**Subject:** Re: Thoughts for 7th November GHS submission - version 2

I write on behalf of Wellingborough Walks Action Group re-Greenhill Solar application EN010170. With the following comments:

Title: Figure 19.1.1 Tree Constraints Plan  
Green Hill A Sheet 1

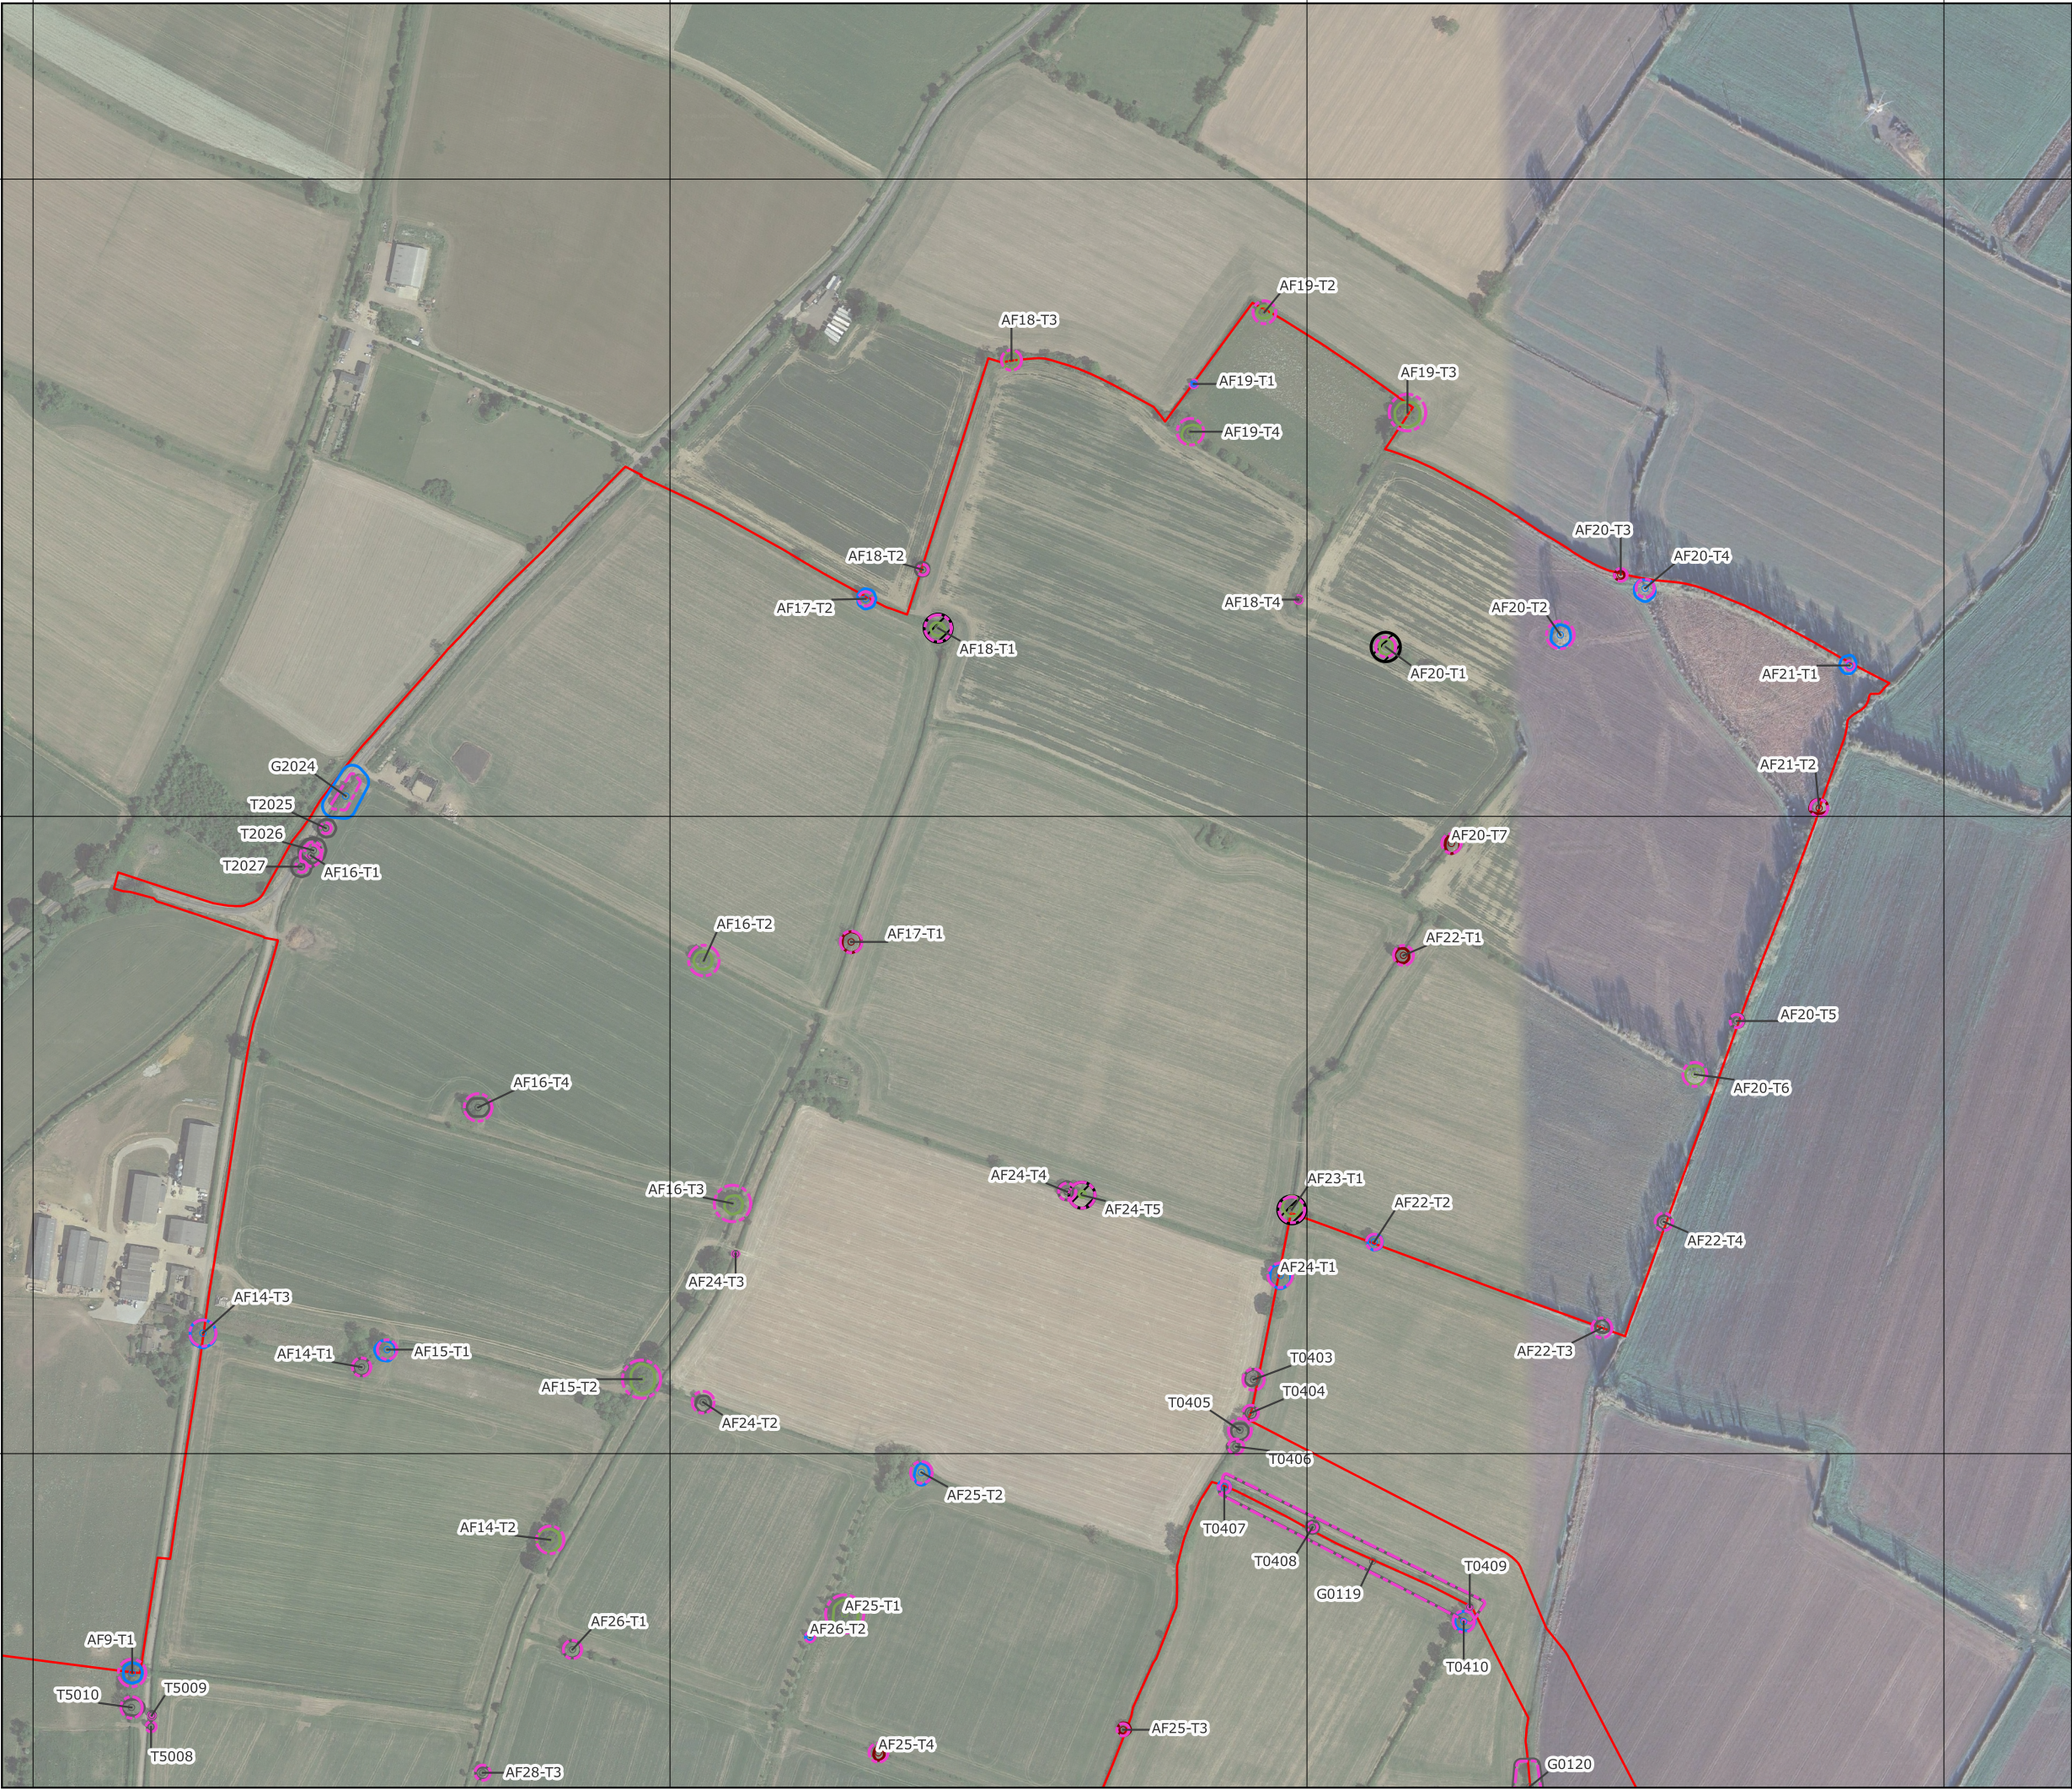
**(1) Mitigation Proposals** - the planned mitigations seem positive as are the Applicant's commitment to protect ancient, veteran and category A trees. However, given the very small number of trees of these trees onsite, and the large number of category B, C and U trees of good quality present, it is still likely that a significant loss of healthy trees across the site will occur.

Title: Figure 19.2.6 Tree Impact Plan
Cable Route Corridor Sheet 2

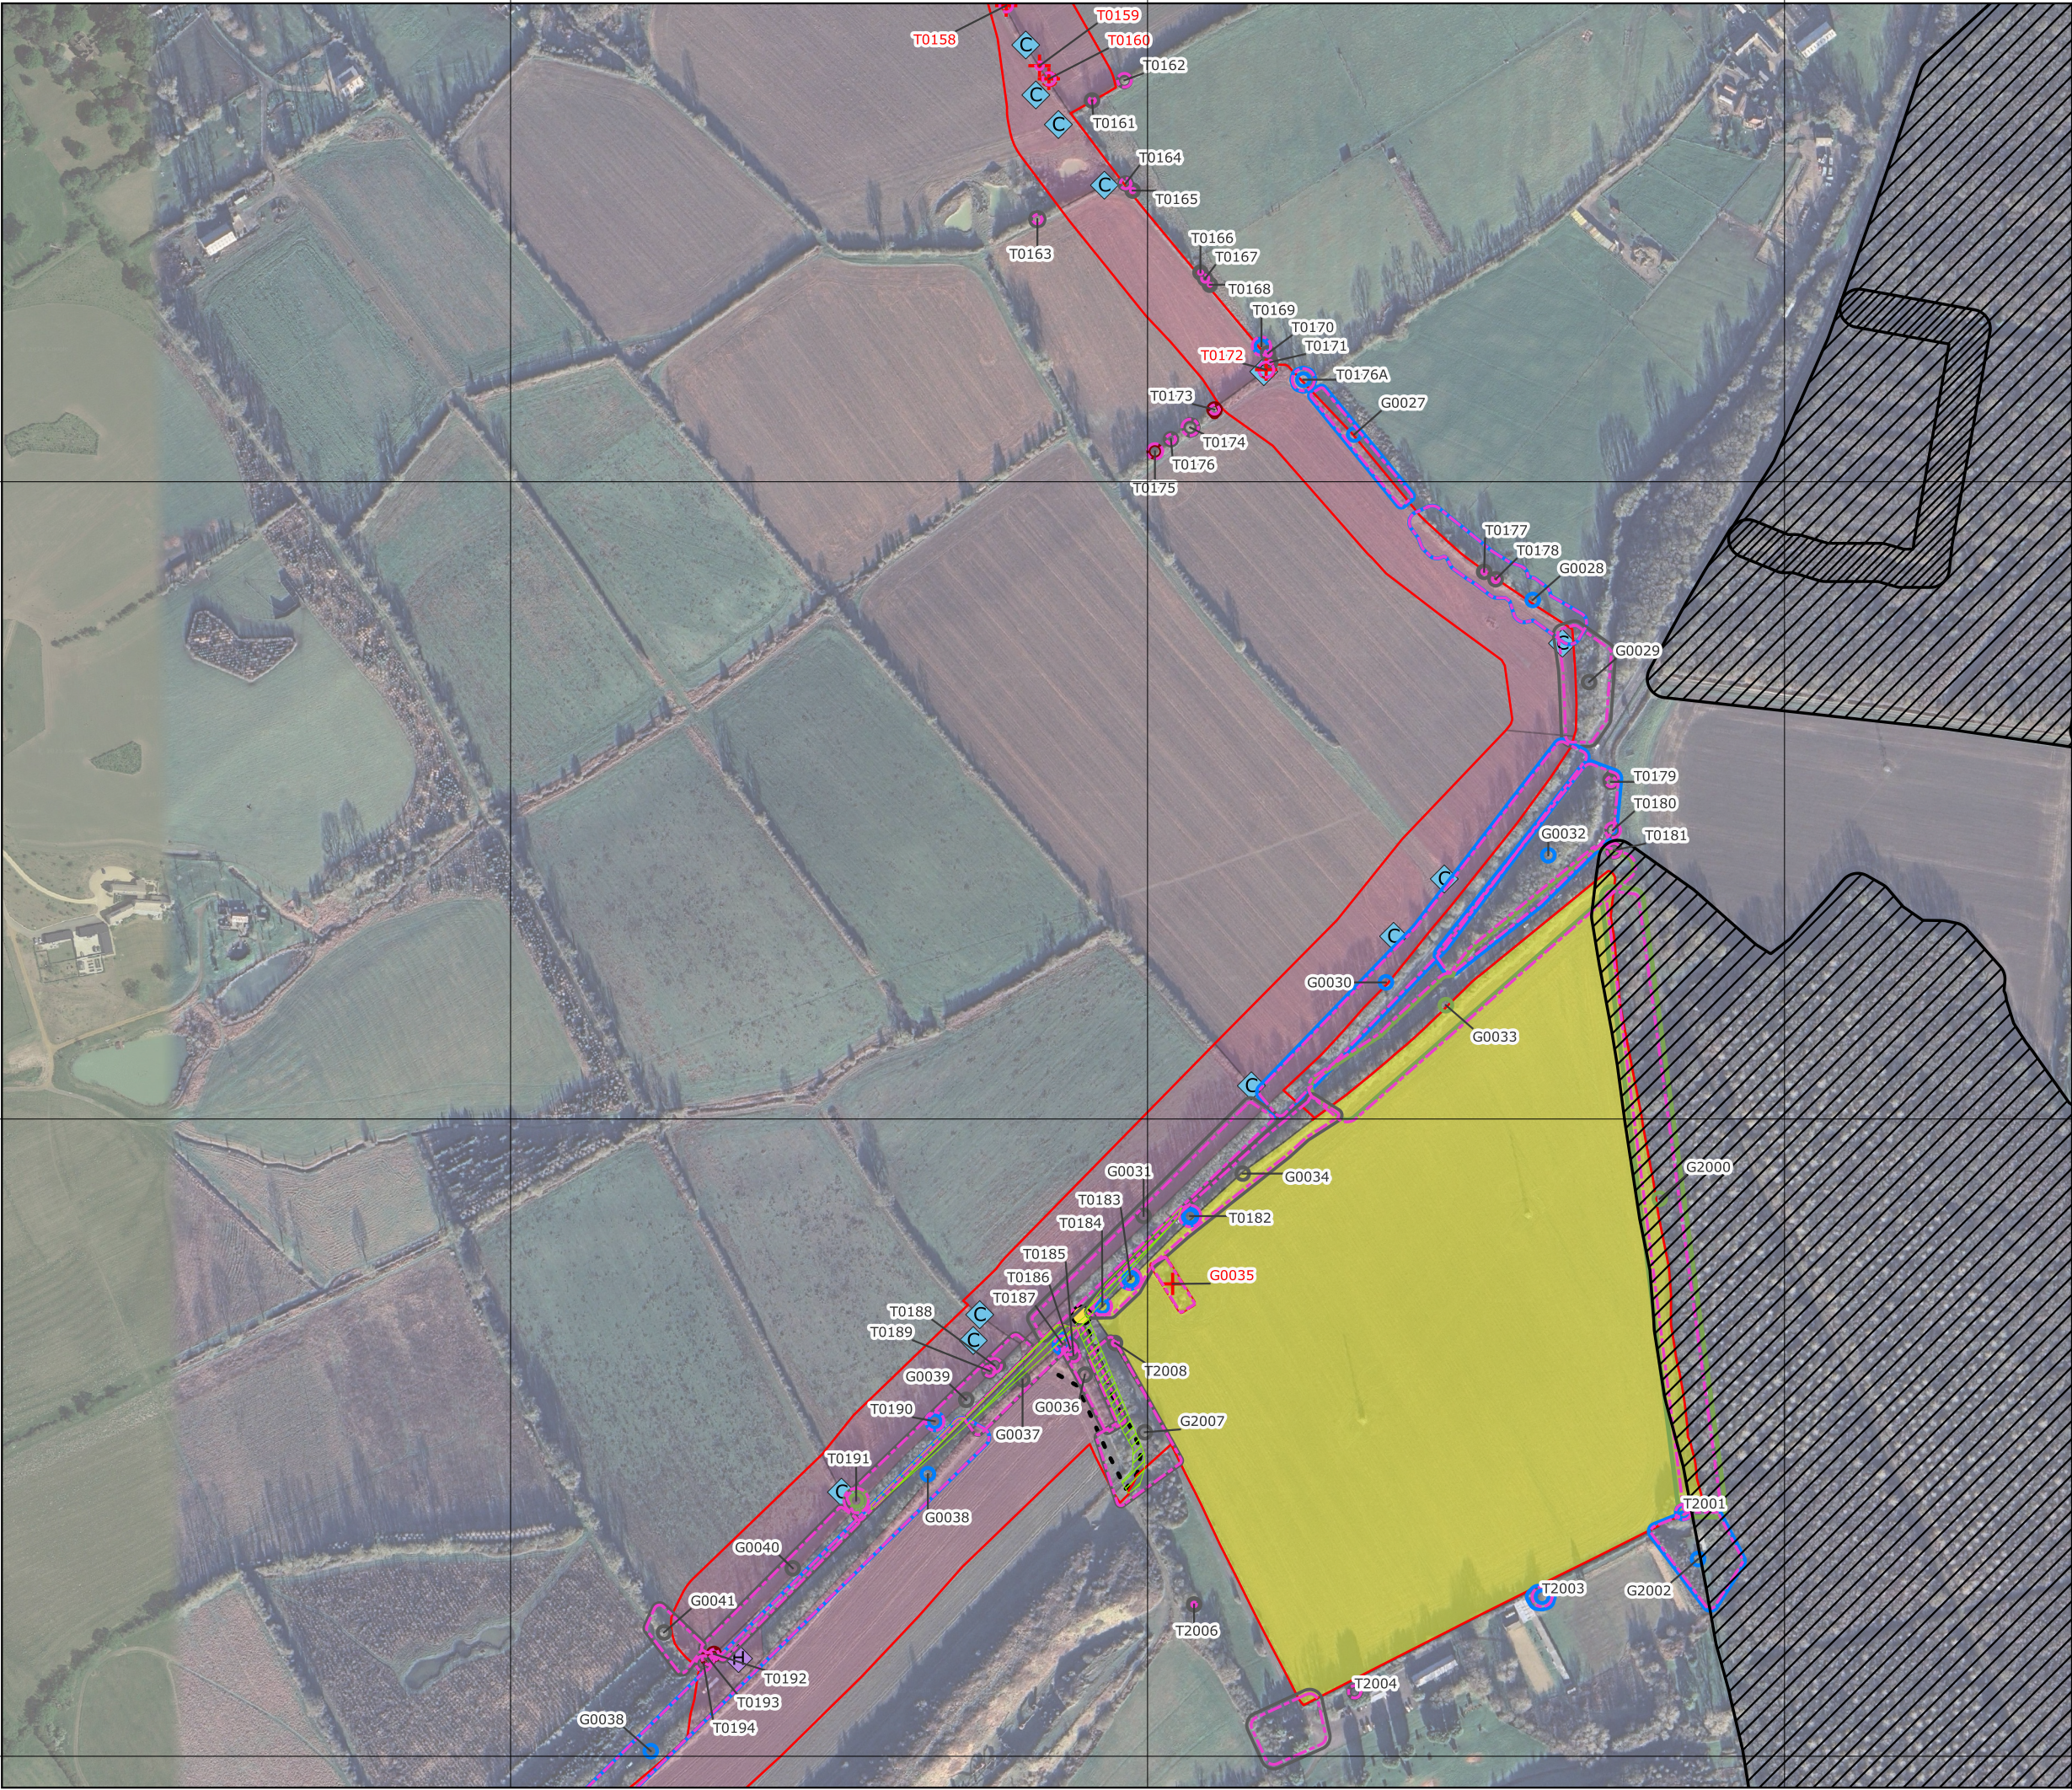
**(2) Cable Corridor Impacts** - the process that will most impact non-ancient/veteran trees is work on the cable corridors. We had expected access to fields to have the highest impact, but from analysis it looks like over 80% of possible tree losses will come as a result of cable corridor creation. This is surprising given the many mitigation techniques the Applicant is committing to use to safeguard trees, such as micro-siting, HDD trenchless digging and using the 50m corridors to 'avoid' and protect trees. The Applicant is committed to use these techniques for ancient, and category A trees, but less so for category, B, C and U trees.

**(3) Likely Impacts on Site Trees** - From our analysis it appears that 2,665 trees are on site (974 individual and 1,690 trees in 169 groups, assuming ave of 10 trees per group) (ref APP 171 - point 4.2, p23), and roughly 368 healthy mainly cat B and C trees may need to be felled (78 individual, and 290 in 29 groups) (ref - APP 056, table 19.11, p37). This equates to 14% of all trees. And when further potential impacts noted in table 19.12, on p39 of APP 056, are added, ie. root and canopy impacts, the trees affected rises to 22% of all trees, a staggering amount. The Applicant mentions these are 'worst case scenario', but they remain worrying high. Northamptonshire already has one of the lower tree canopy coverages in England at 10%, (England ave is 12.8%), thus we can ill-afford to lose this amount. Clearly, if the Applicant decides to use

mitigation measures for the cable corridor to protect more category B and C trees, the losses could be significantly lower.
